CITY OF ALBUQUERQUE

**RE: RGNC State Park Parking Lot
Grading & Drainage Plan
Engineer's Stamp Date 11-18-2015 (File: F12D001)**

Based upon the information provided in your submittal received 11-19-15, the above referenced plan is approved for Grading Permit with the following conditions/comment:

SITE GRADING &
DRAINAGE PLAN

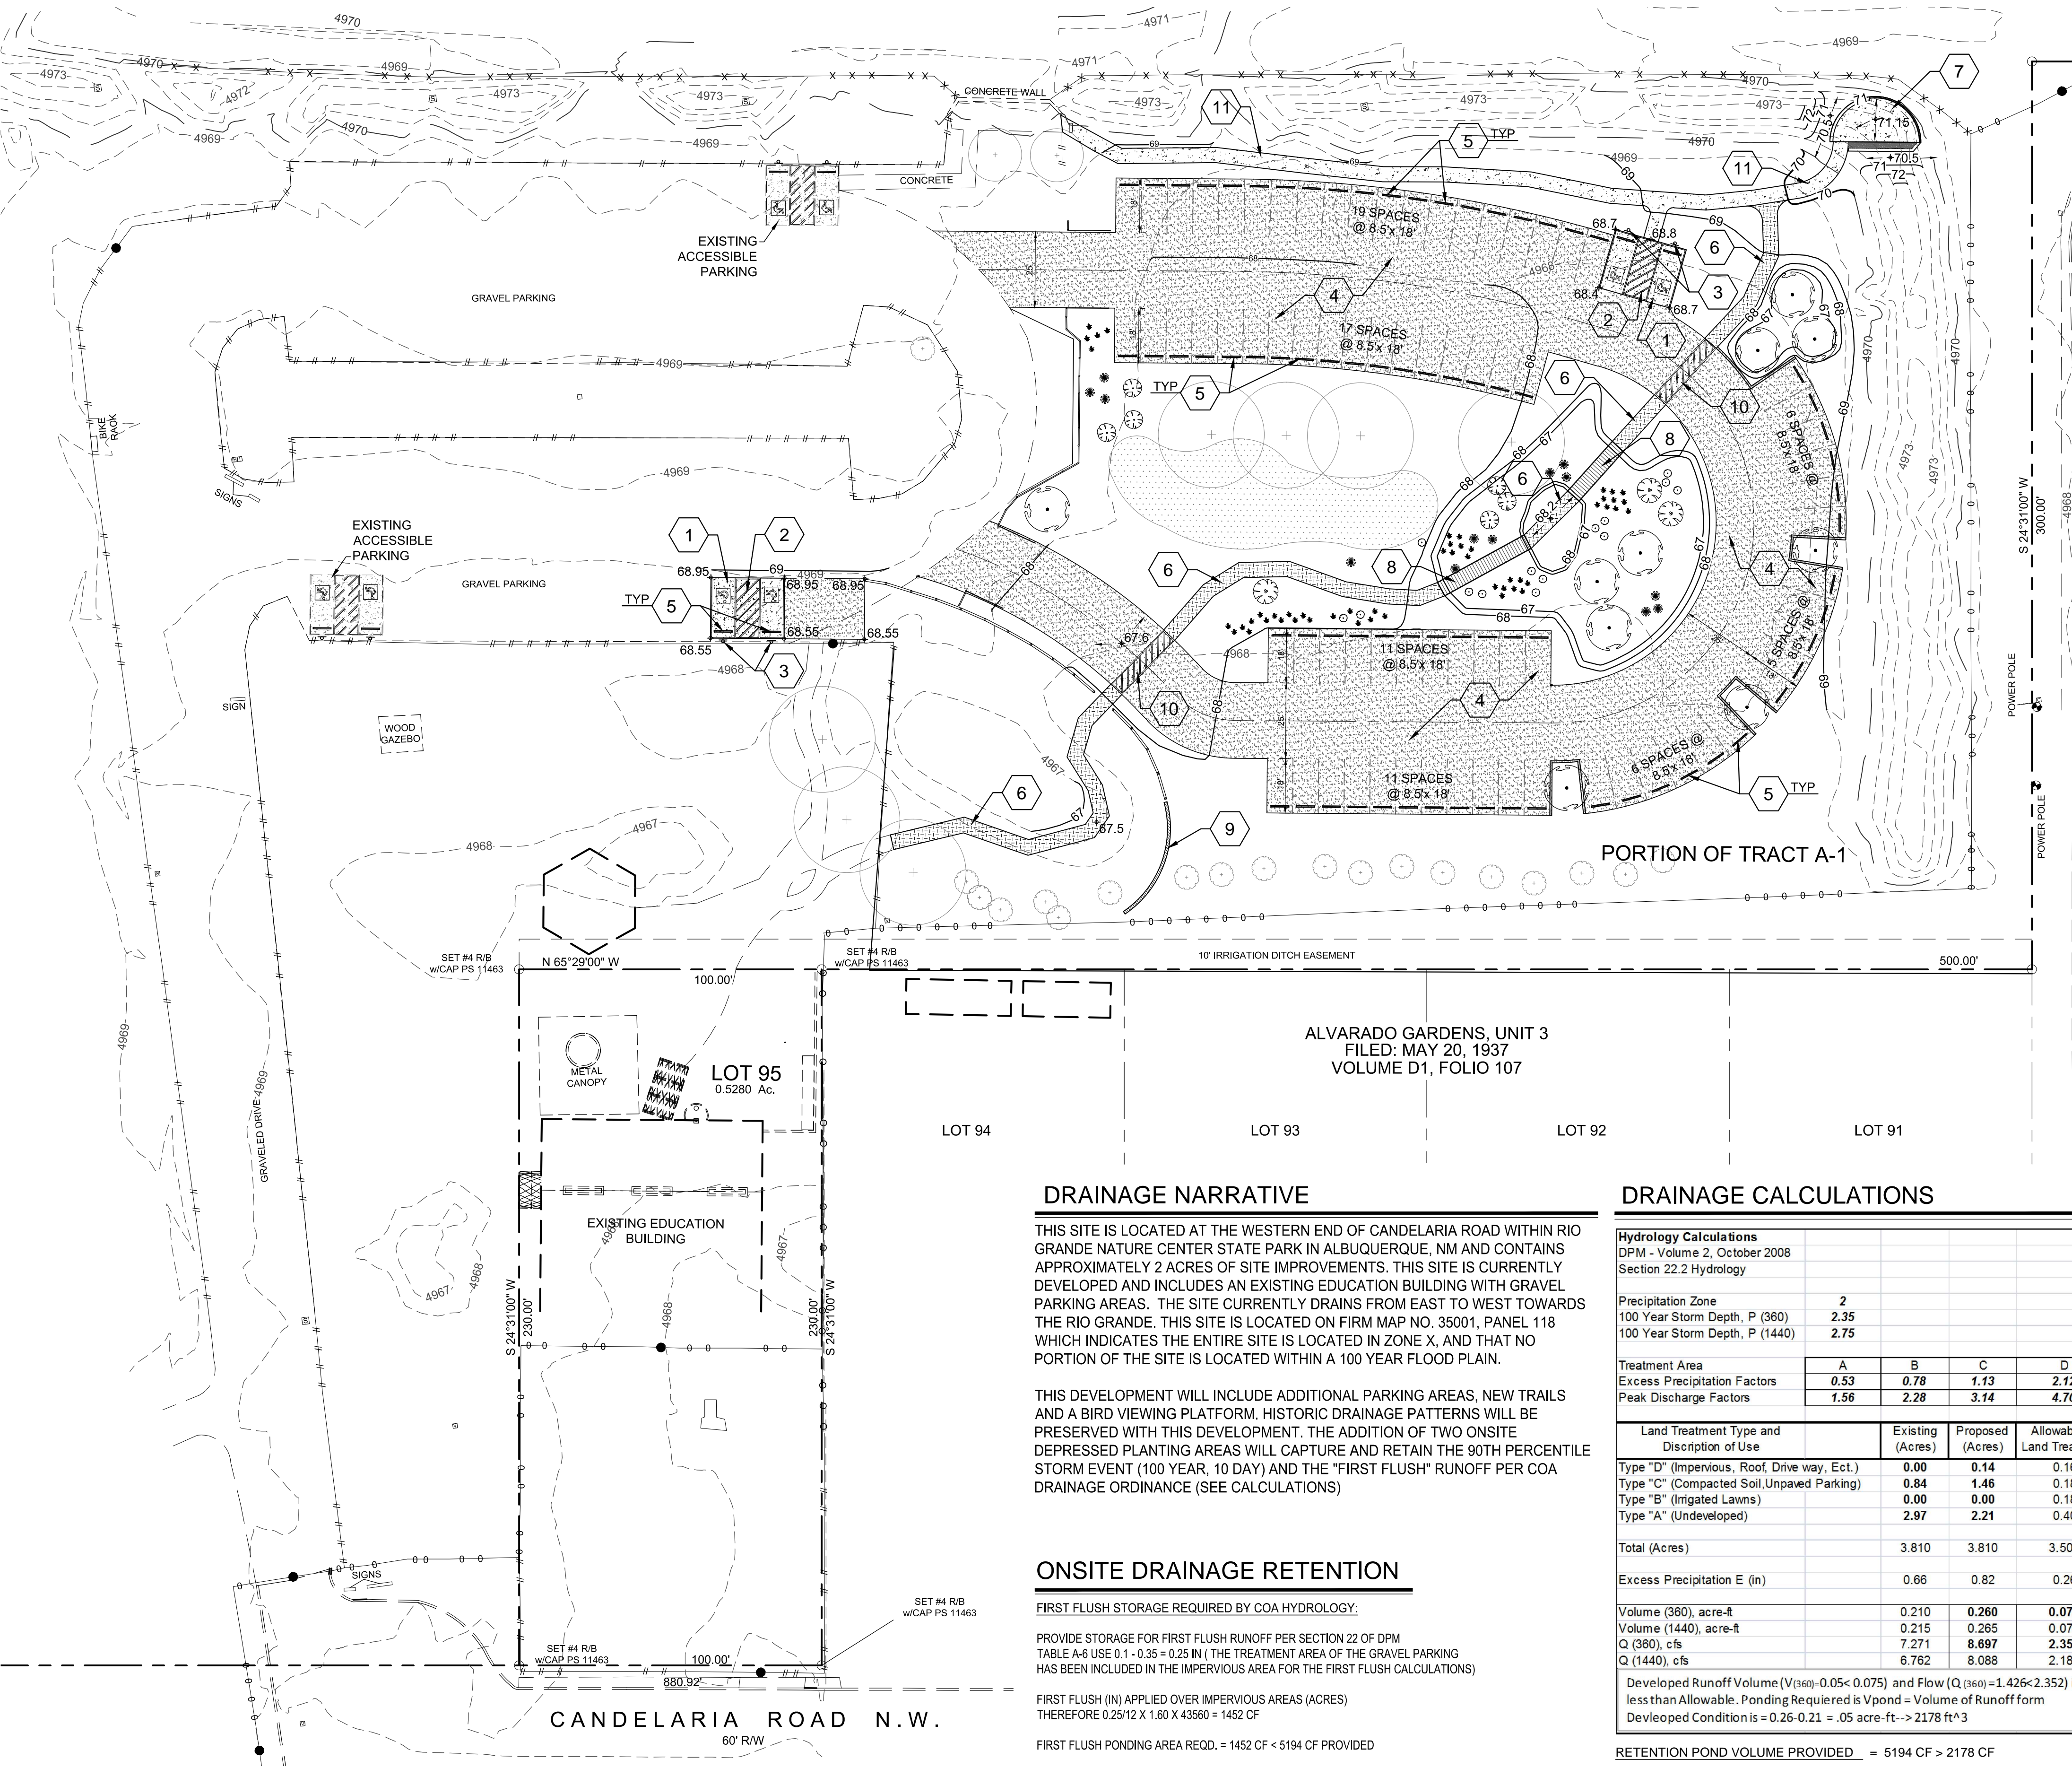
1. The existing parking site is 1.81 with the proposed expansion being 2 acres, for a total of 3.81 Acres. The existing site is gravel and flat, so it appears runoff either infiltrated, or flowed to a low area on the proposed expansion. This historic drainage pattern must be maintained. The submitted plan shows that the low area is not being reduced in volume. If fact a shallow pond shows that additional volume (5194CF-2178CF = 3016 CF) is being provided which is an improvement of current conditions.

2. However, there is not in our records a grading plan for the existing lot, and volume for the 100-yr storm should have been retained within the property boundaries. In order to protect the lots to the south, provide a berm along the south property line that would contain the volume for the entire site based on the 100-yr storm. Show the berm on the as-built plan with the Engineer Certification which is to be submitted at the completion of the project.
